The Sizewell C Project

9.120 Comments on Earlier Deadlines, Subsequent Written Submissions to ISH11-14 and Comments on Responses to Change Request 19

SIZEWELL C PROJECT –
COMMENTS ON EARLIER DEADLINES, SUBSEQUENT
WRITTEN SUBMISSIONS TO ISH10-14 AND
COMMENTS ON RESPONSES TO CHANGE REQUEST 19

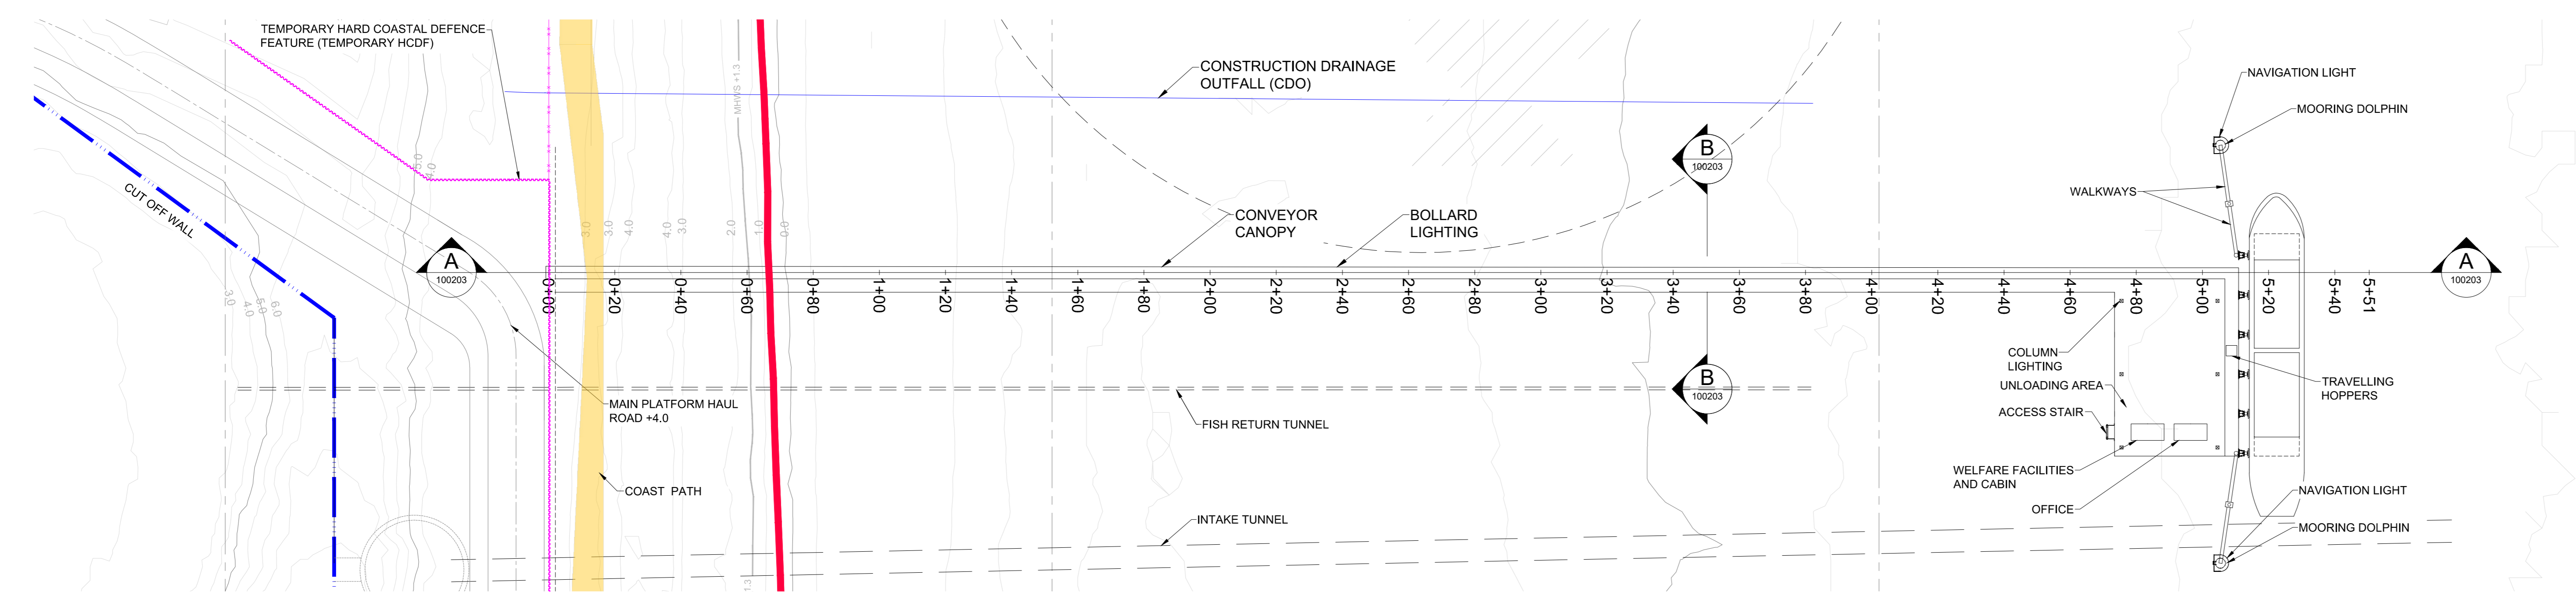
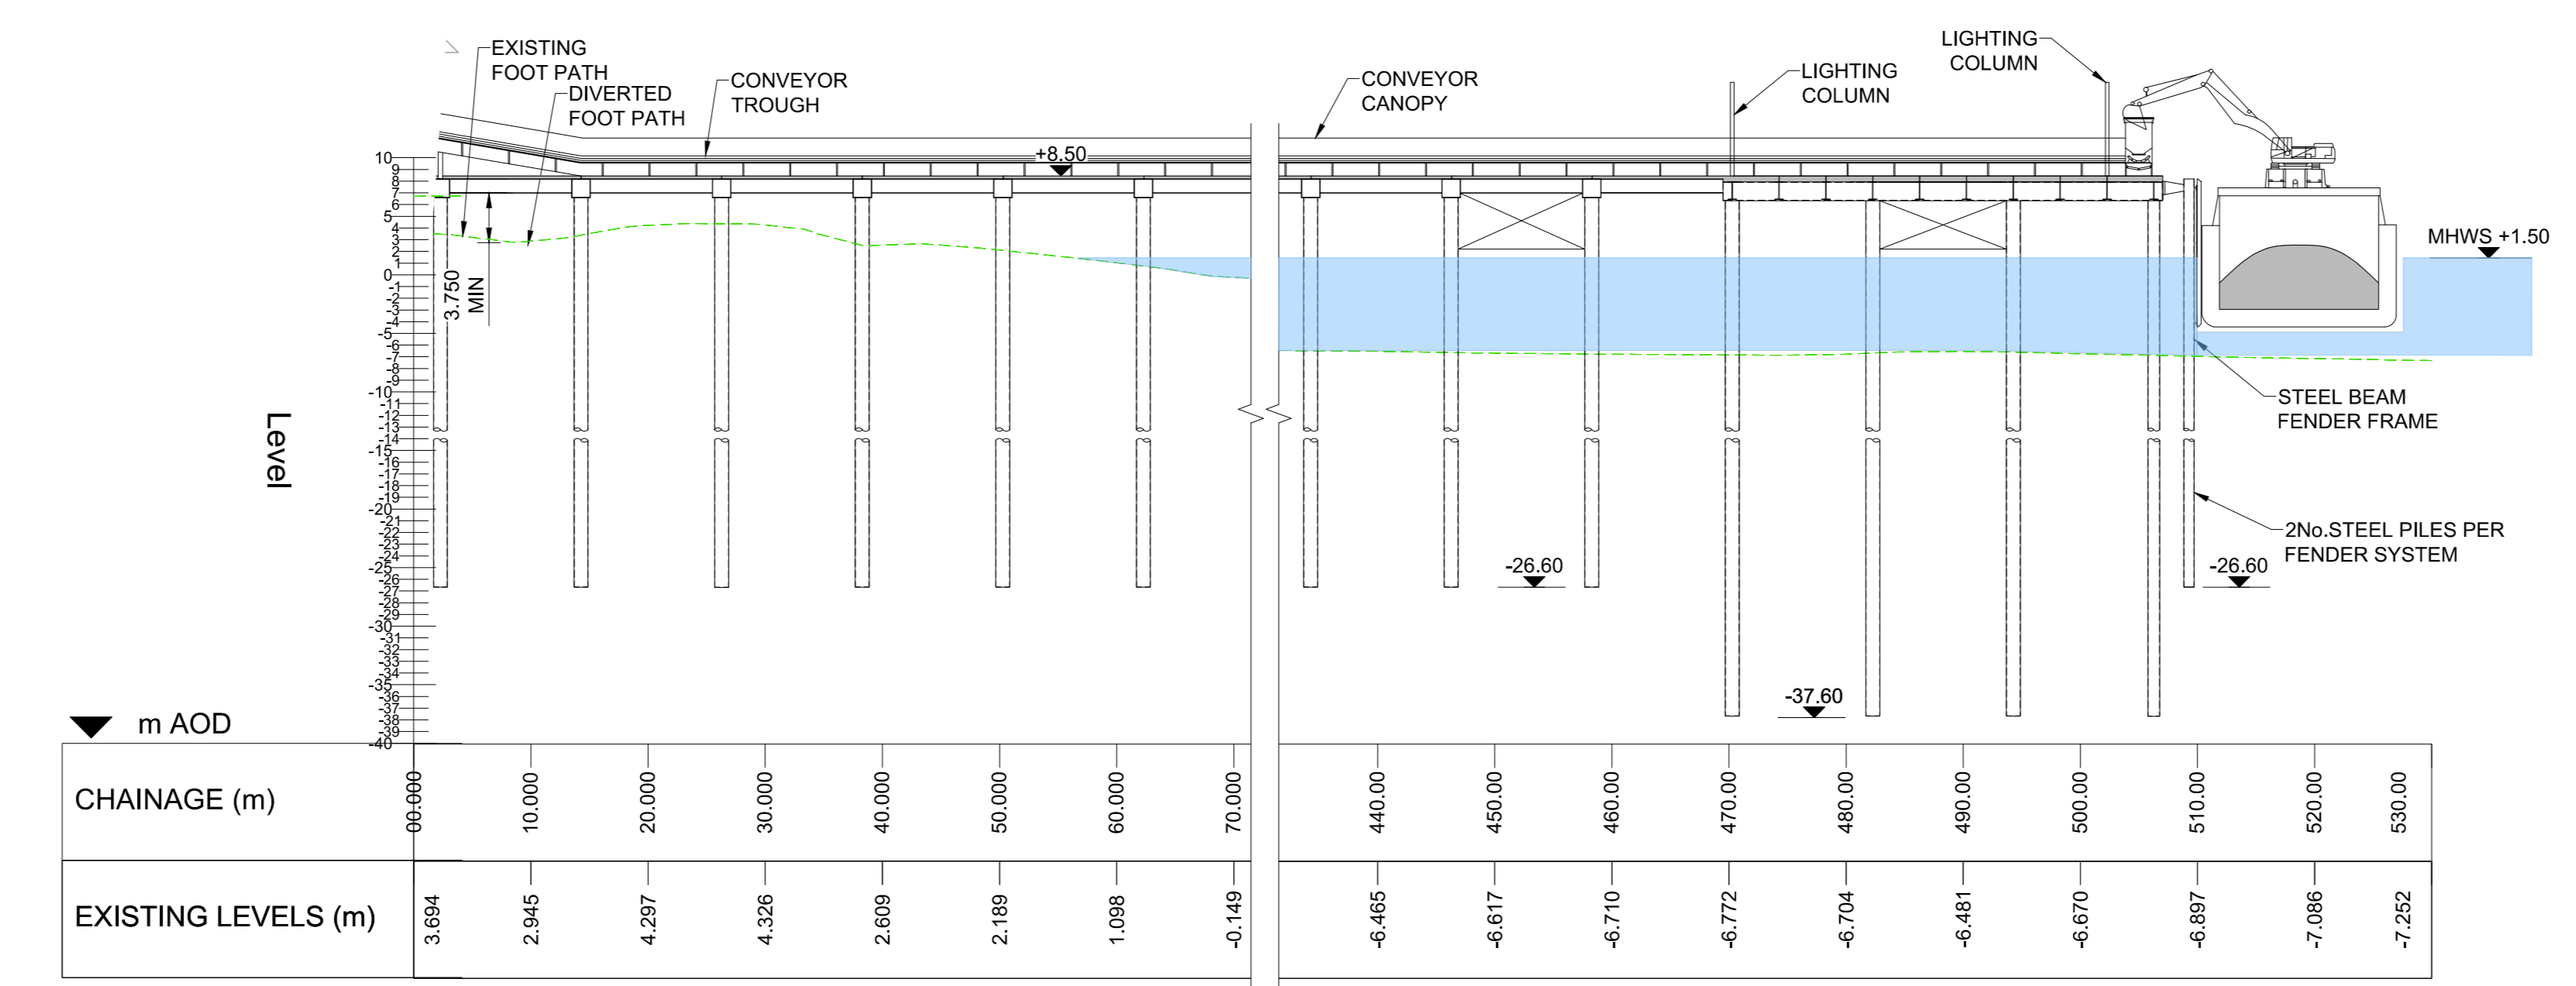
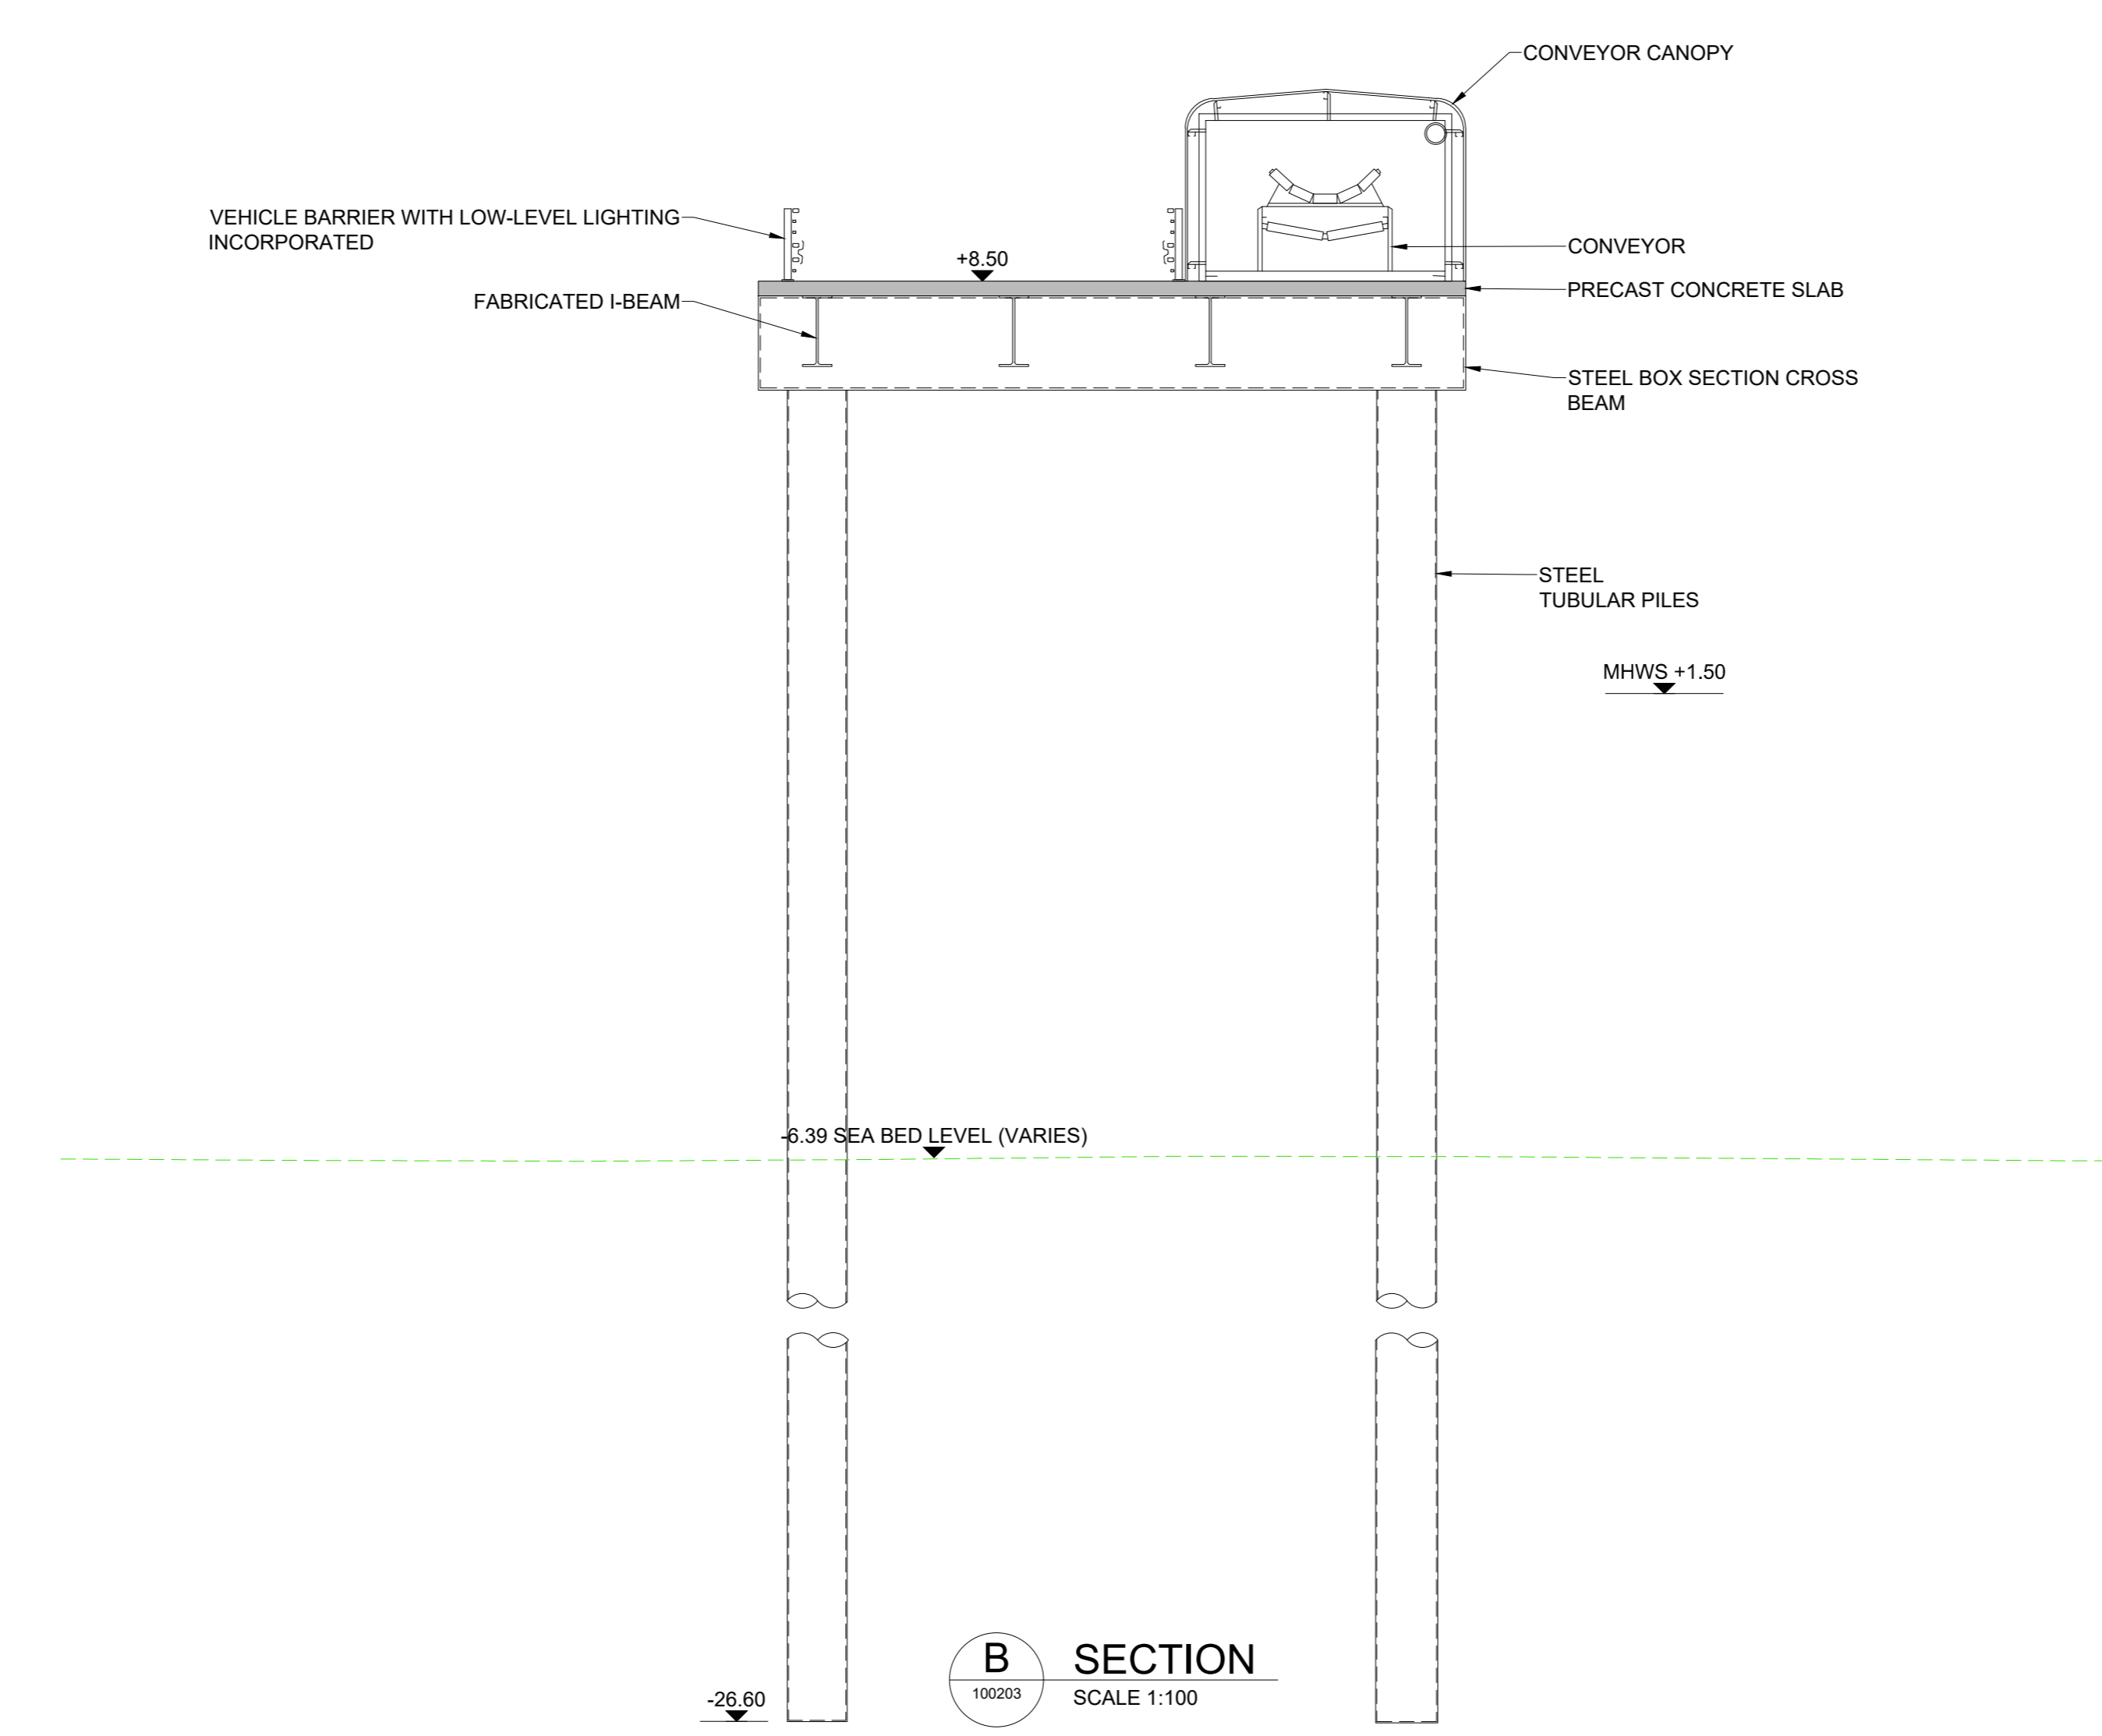
2.3.13 With regards to Main Development Site, Temporary BLF (SZC Construction plan (Ref SZC-SZ0100-XX-000-DRW-100203) (also known as the temporary Marine Bulk Import Facility), ESC requested clarification on the piles within the hard and soft coastal defence.

2.3.14 The temporary Marine Bulk Import Facility (temporary MBIF), will be removed prior to completion of the relevant part of the permanent HCDF and SCDF. Piles will typically be extracted, but whether this cannot be achieved then piles would be cut off. There is therefore not expected to be
